From: Laura Gibbons <Laura.Gibbons@arun.gov.uk>
Sent: 08 June 2021 12:32
To: Planning.Responses <Planning.Responses@arun.gov.uk>
Cc: Michael Eastham <Michael.Eastham@arun.gov.uk>
Subject: A/84/21/DOC

We have the following further comments on this discharge of conditions application.

Condition 23 SuDS details

Condition 28- surface water drainage strategy

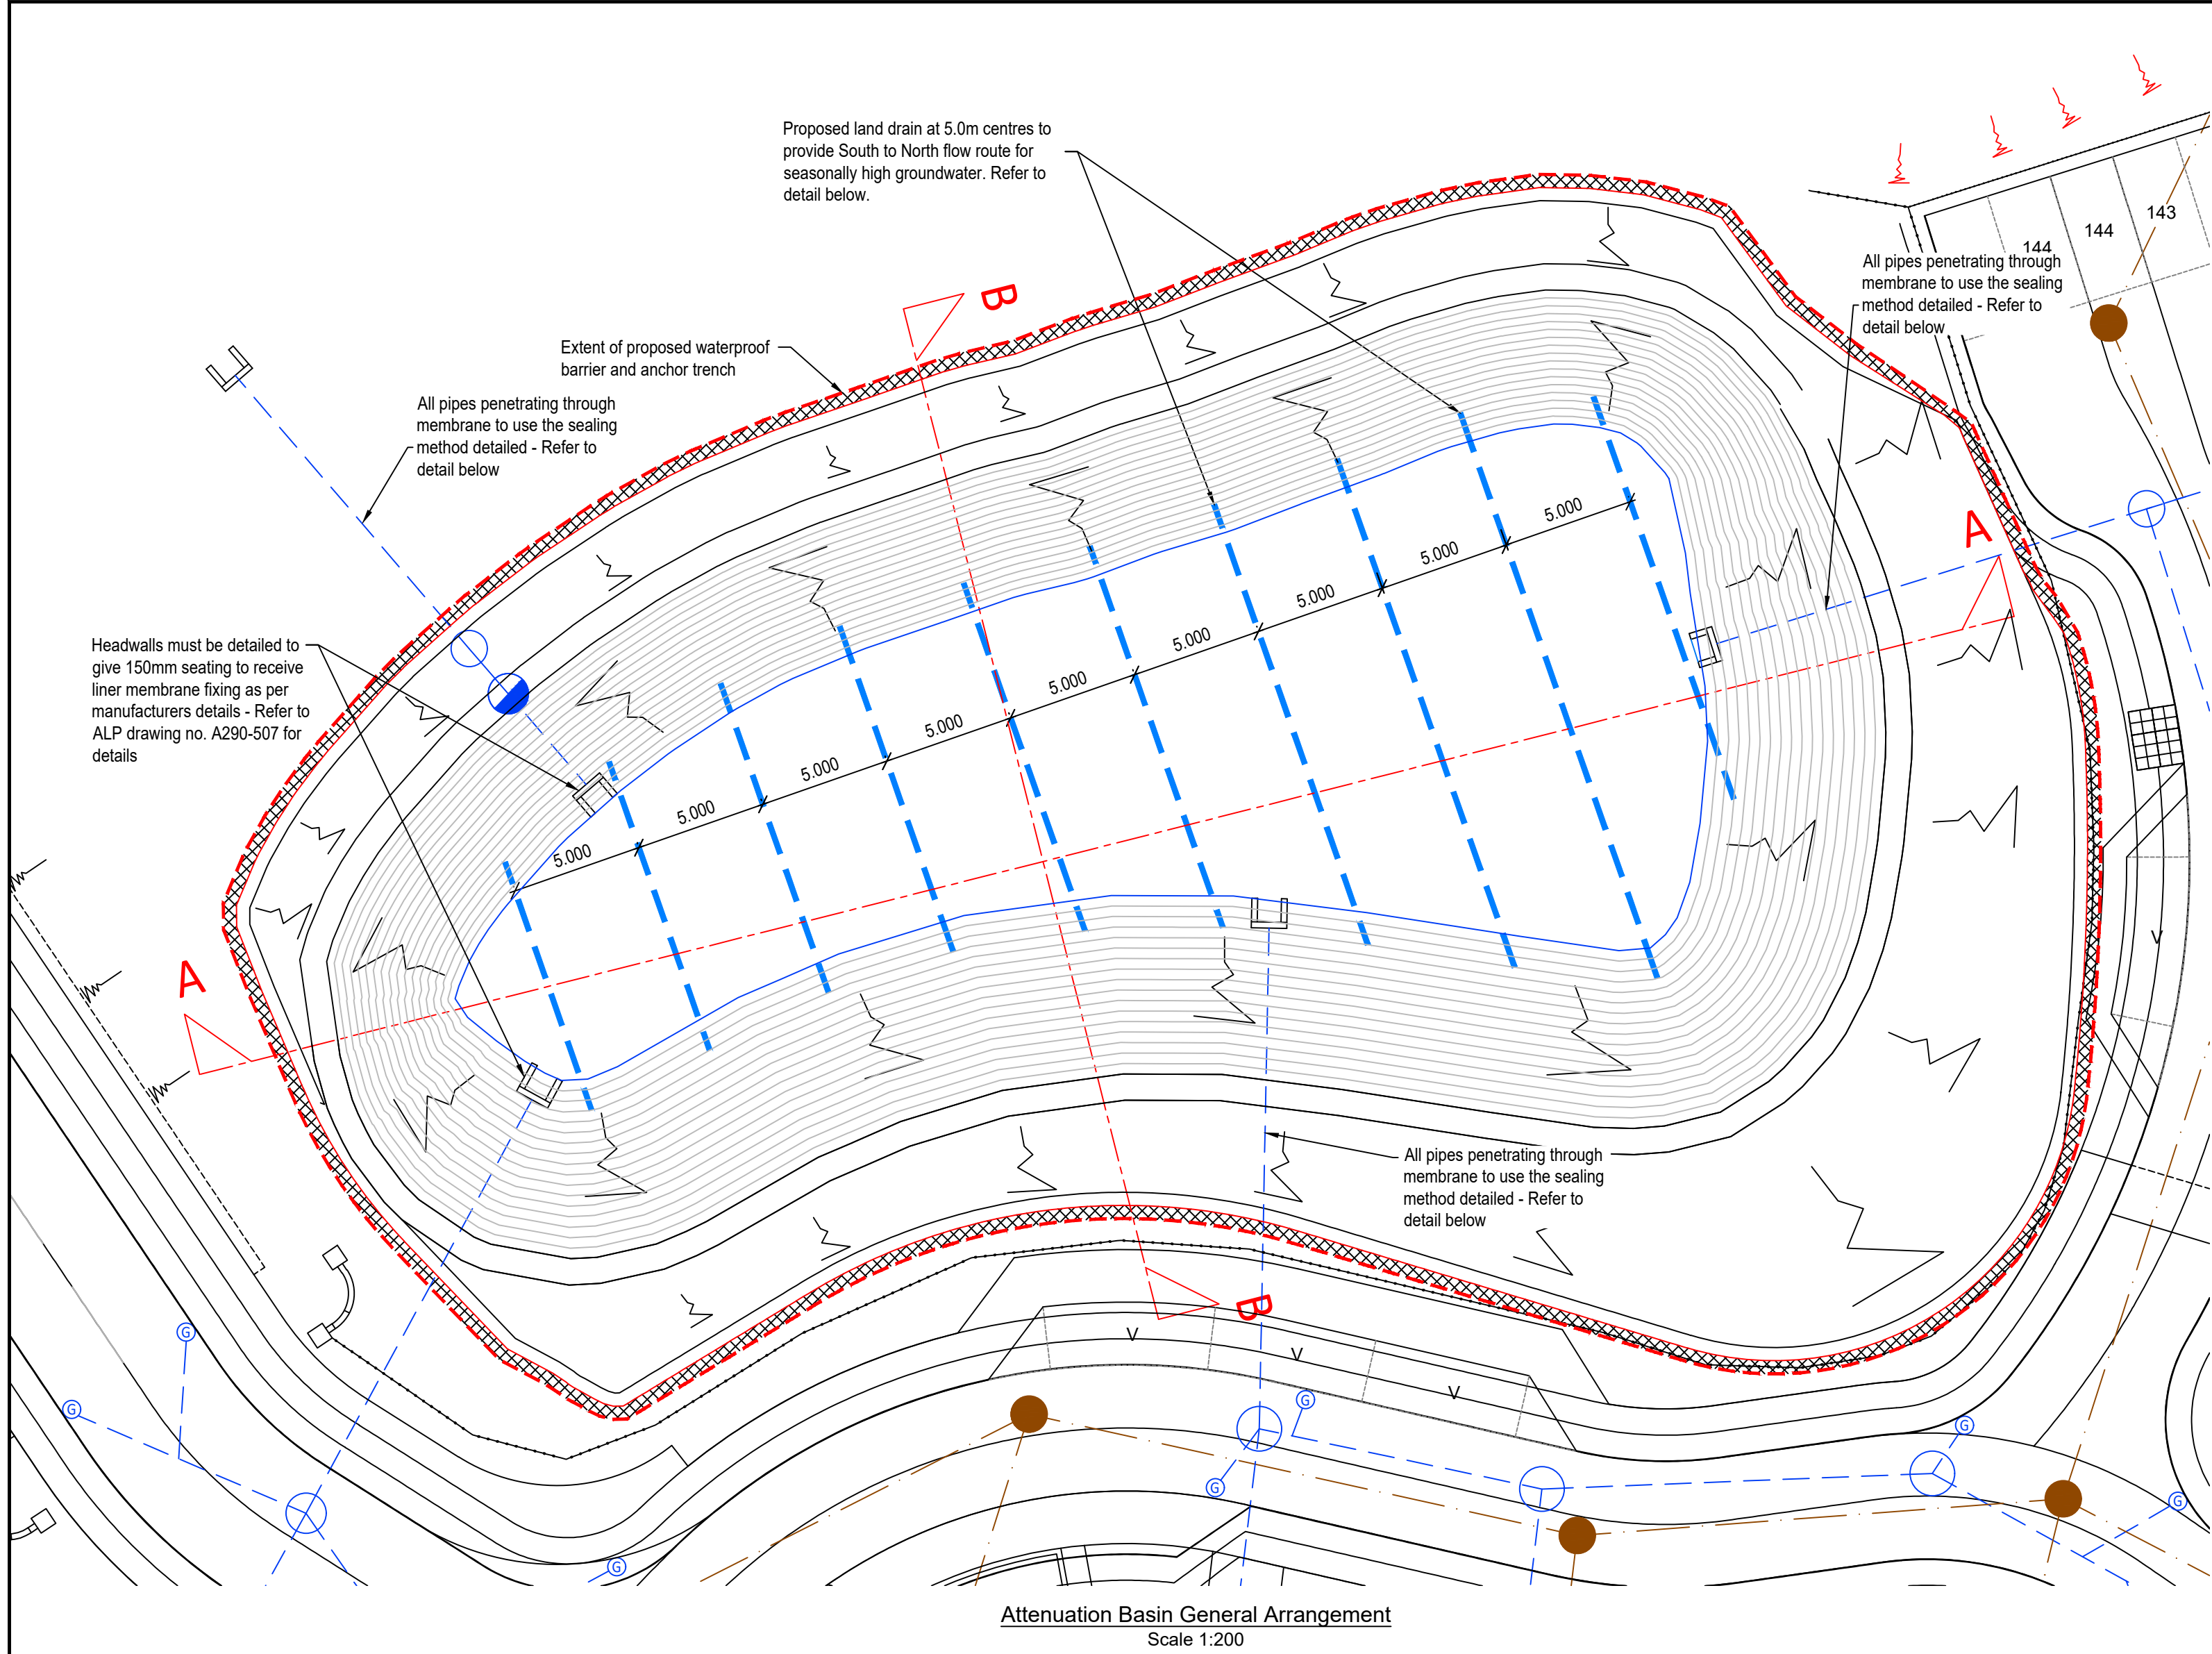
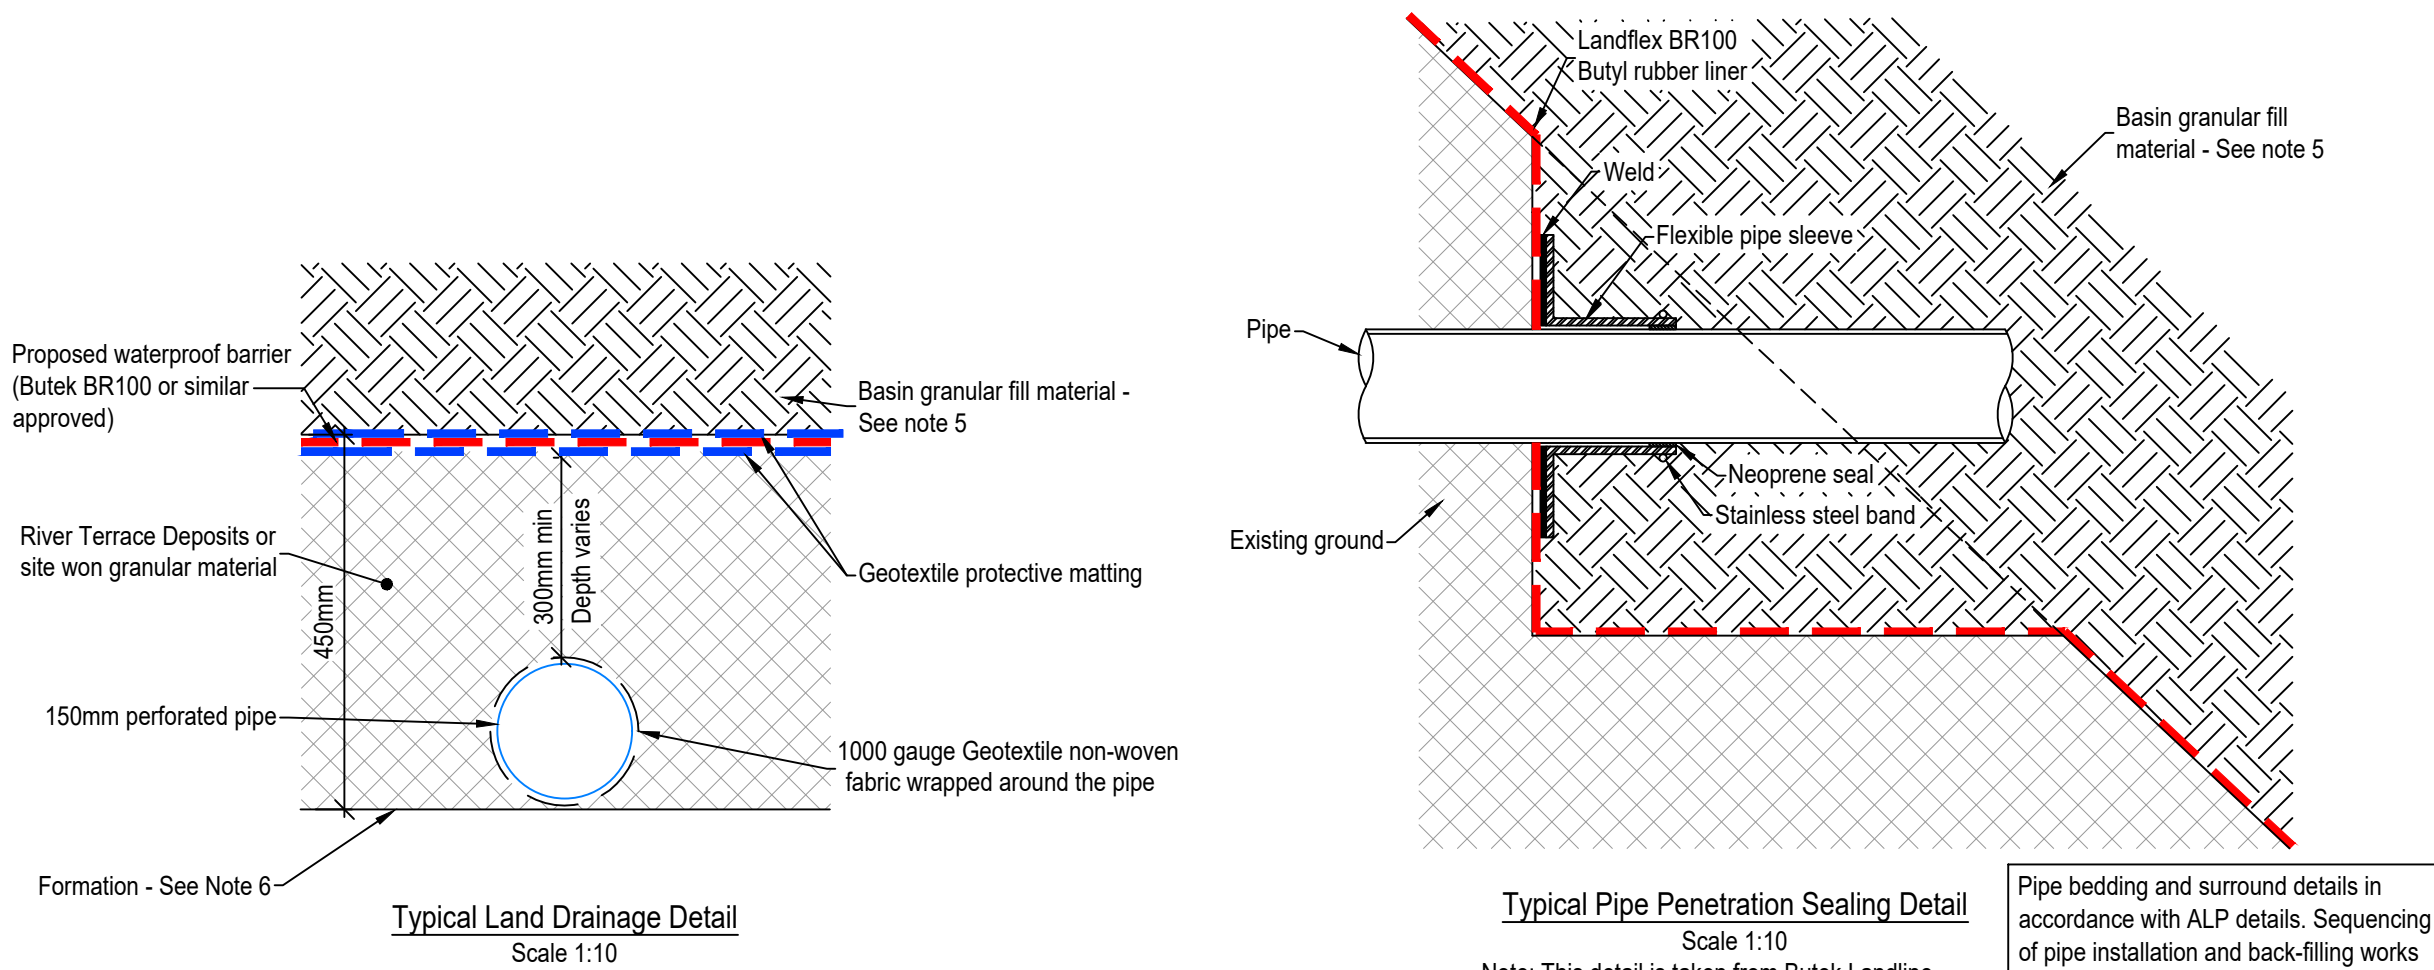
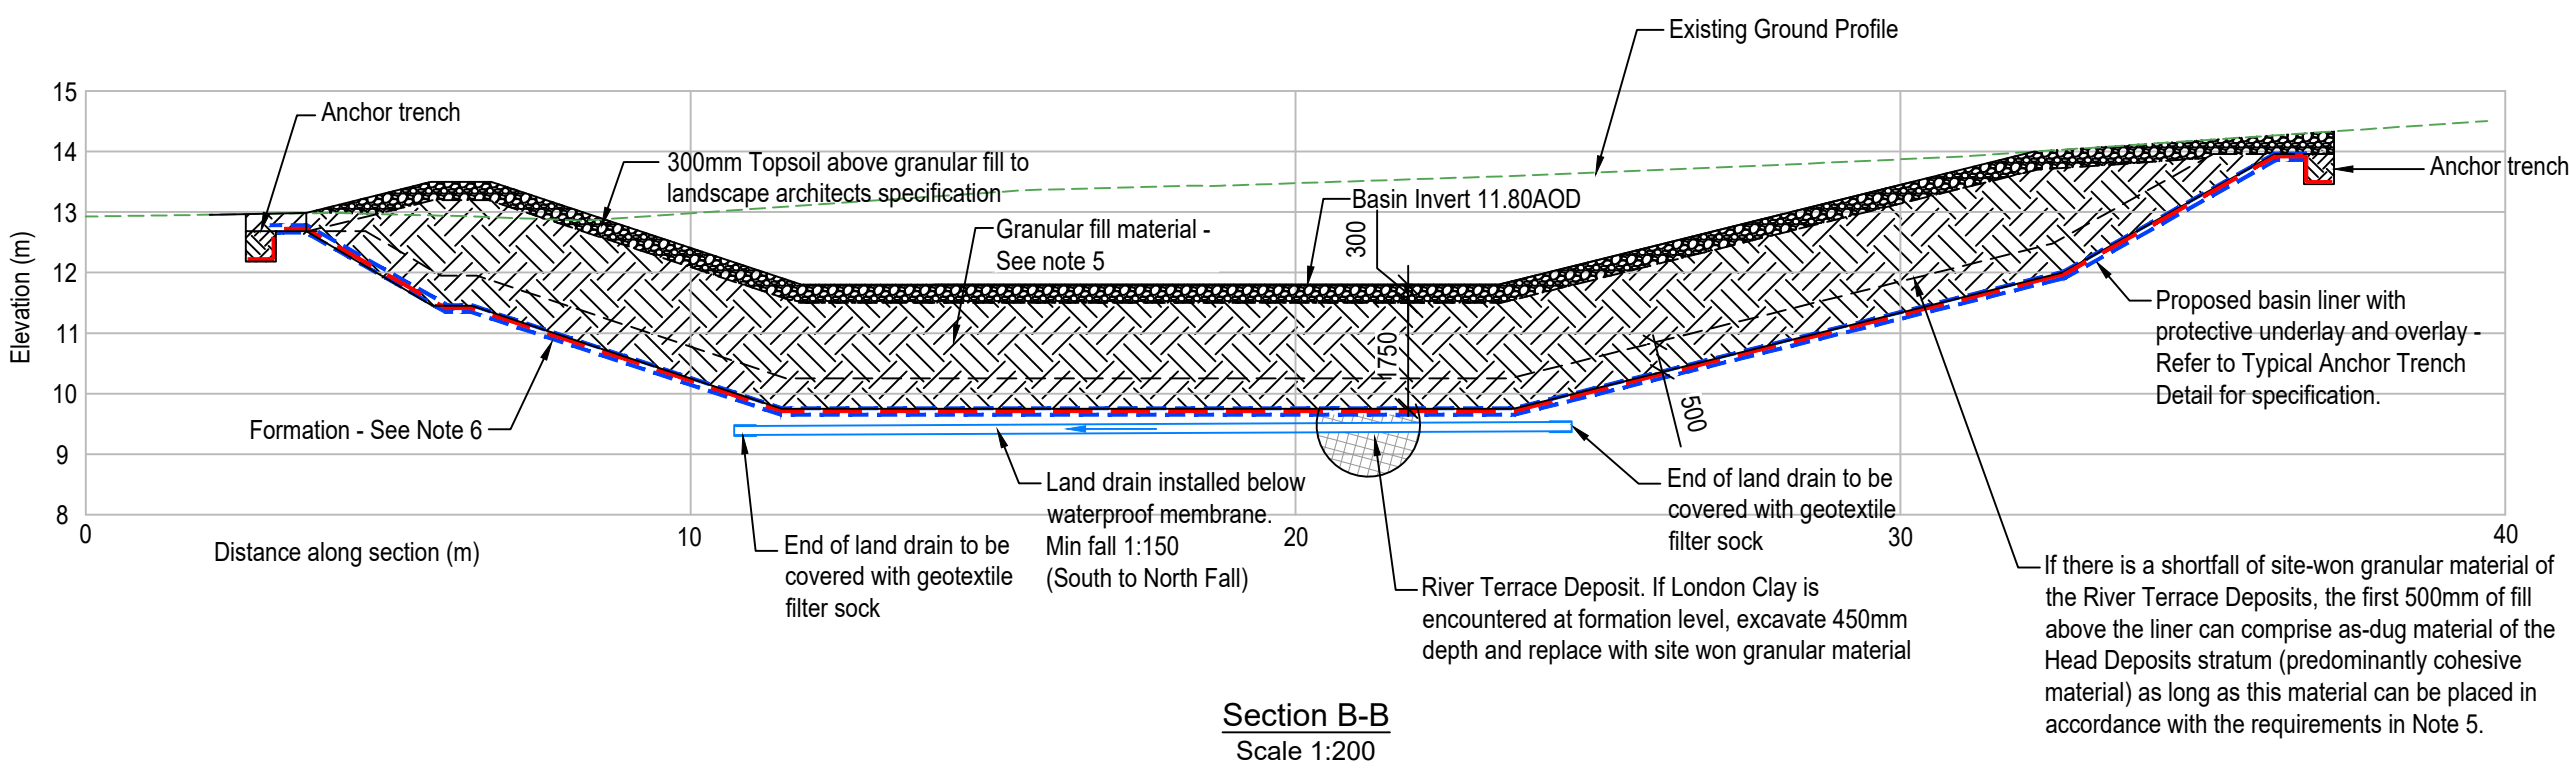
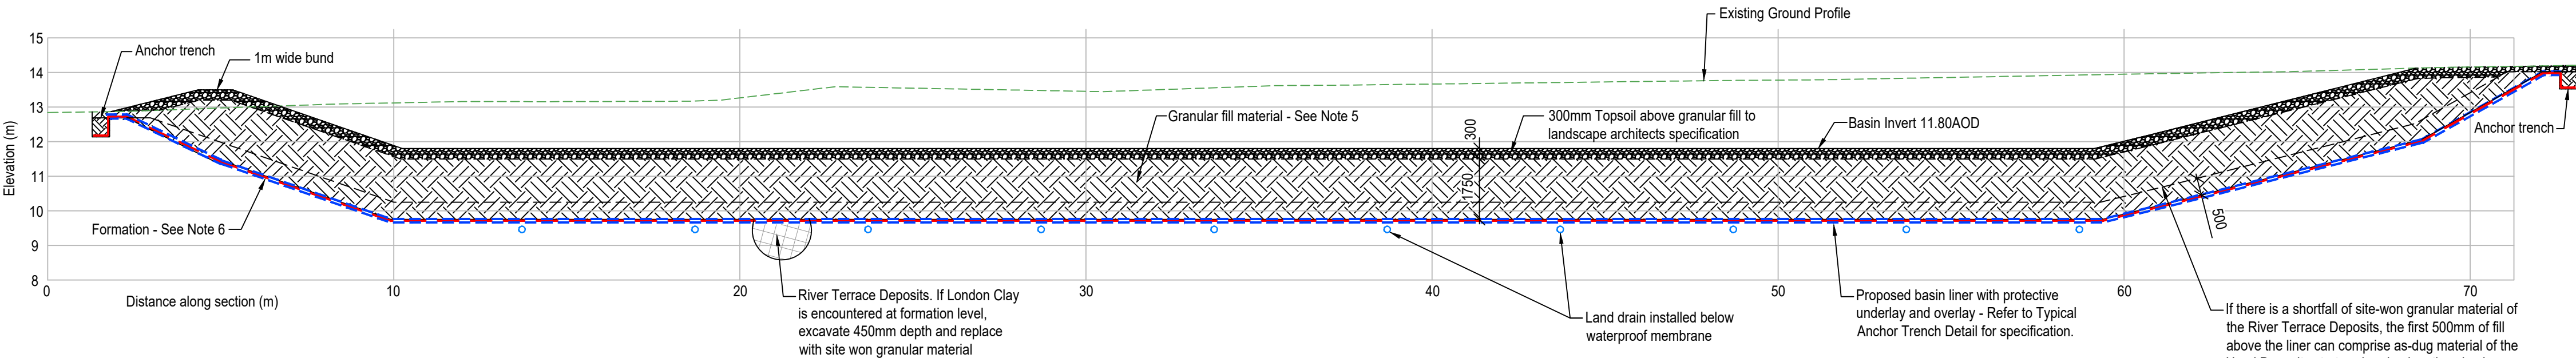
- Design lifetimes of some elements still have not been provided. For example the lifetime of the impermeable liner to the attenuation basin and tank must be stated along with requirements to check its condition and for replacement.
